February 23, 2016

Ms. Jean Fraser City of Portland Planning 389 Congress Street Portland, ME 04101

Subject: 421 Warren Avenue Site Plan Revision Email Comments Received by Jean Fraser Dated February 16, 2016 Letter of Response #1

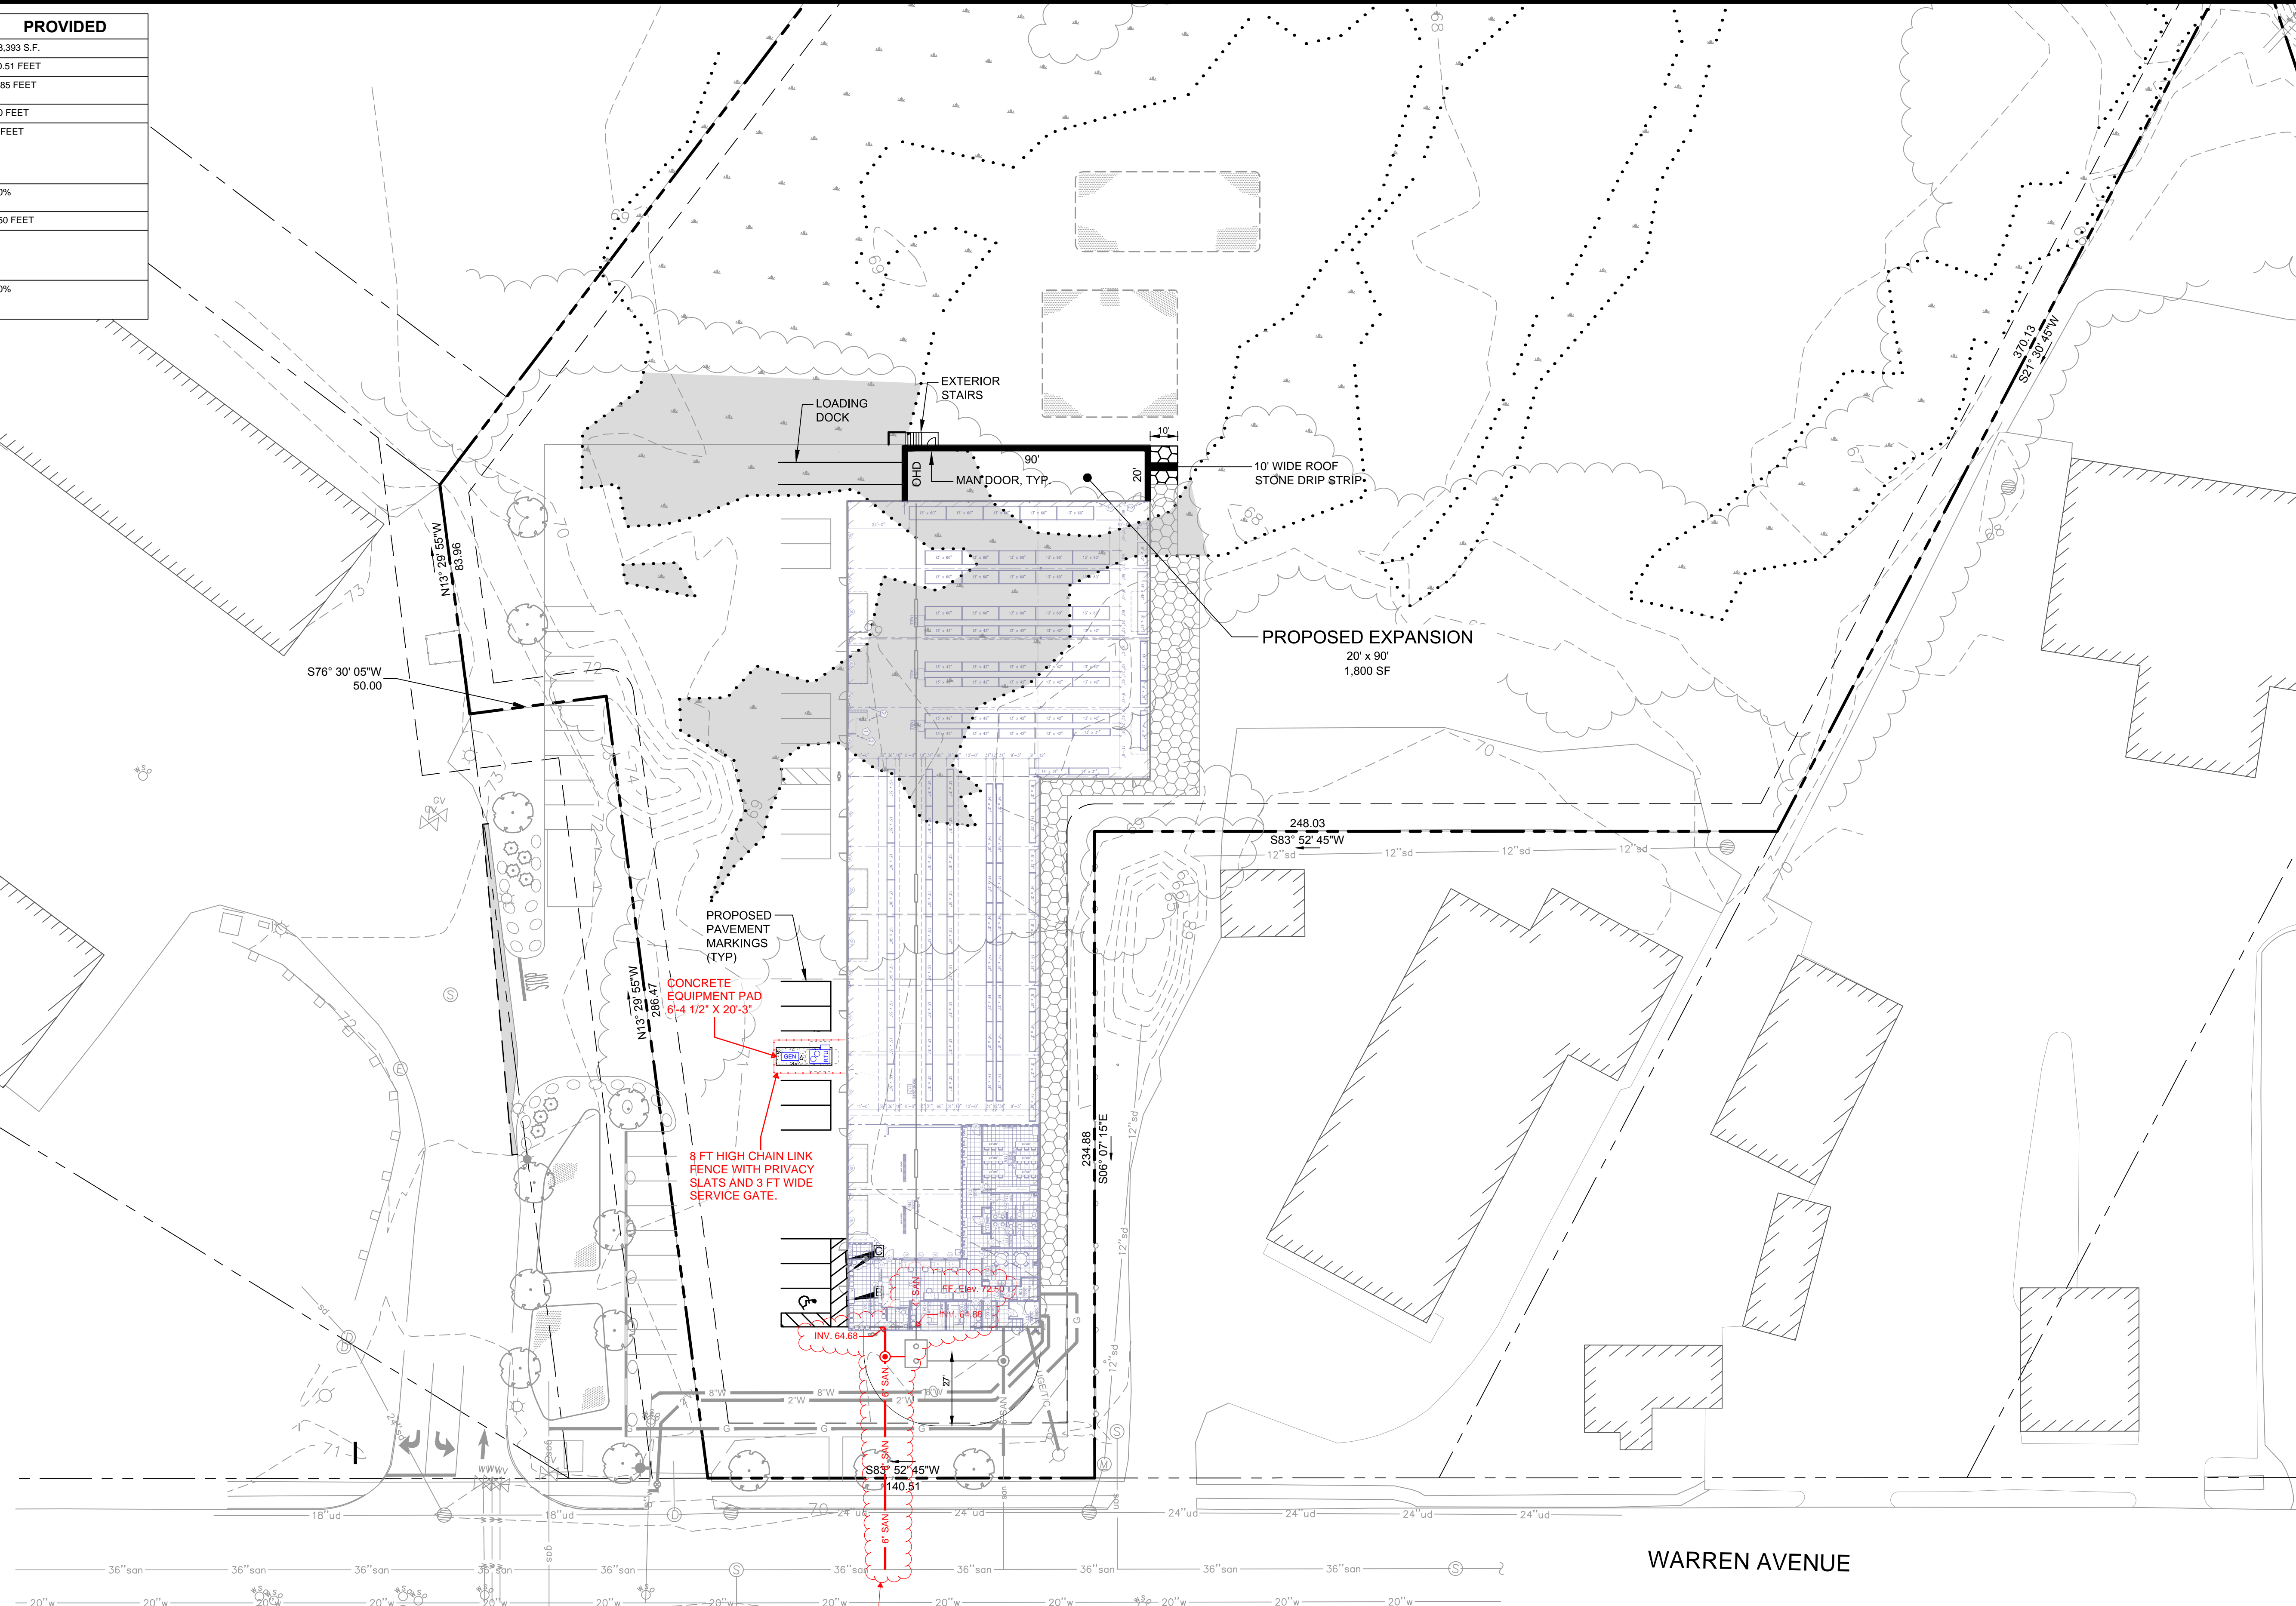
Location and baffling of the new generator: The B4 zone includes noise limits of 60 DbA night and 65 DbA day and its location so near the boundary may make that difficult. Also it needs some kind of screening or enclosure. I would like to see the specs for the sound generation (when operating) for that unit as my experience tells me it may be too close to the boundary. Could it go farther back on the site?

Parking: Please amend the site plan (attached) so that there is no parking shown in front of the garage doors and main entrance for the two bay in-shop area for glass repairs with a customer waiting area. The area in front of the entrance door should be striped and ideally there should be ADA access and ADA parking for customers waiting to go into the bay. Maybe a sign saying "customer parking" so those spaces get reserved?

The specifications associated with the proposed generator accompany this letter. The noise levels associated with the generator are as follows:

- Exercising at 7 meter (23') = 54 dba
- Normal operation at 7 meters (23') = 60 dba

The generator is to be used only in emergency situations and thus we believe its operating noise level is well within acceptable levels. Further, the generator is located to the side of the building. The nearest building (containing Harbor Auto Body) is located approximately 72 feet to the east and that building is also owned by Peter Holmes, who has indicated no objection to the placement of the generator. For these reasons, we see no need to relocate the generator.

The Site Plan has been modified to realign the parking area striping to avoid conflict with overhead and entry doors. We have also added an ADA space at the front of the office area. The site will contain at least 35 parking spaces which is considered more than enough for the intended use and expected parking demand.
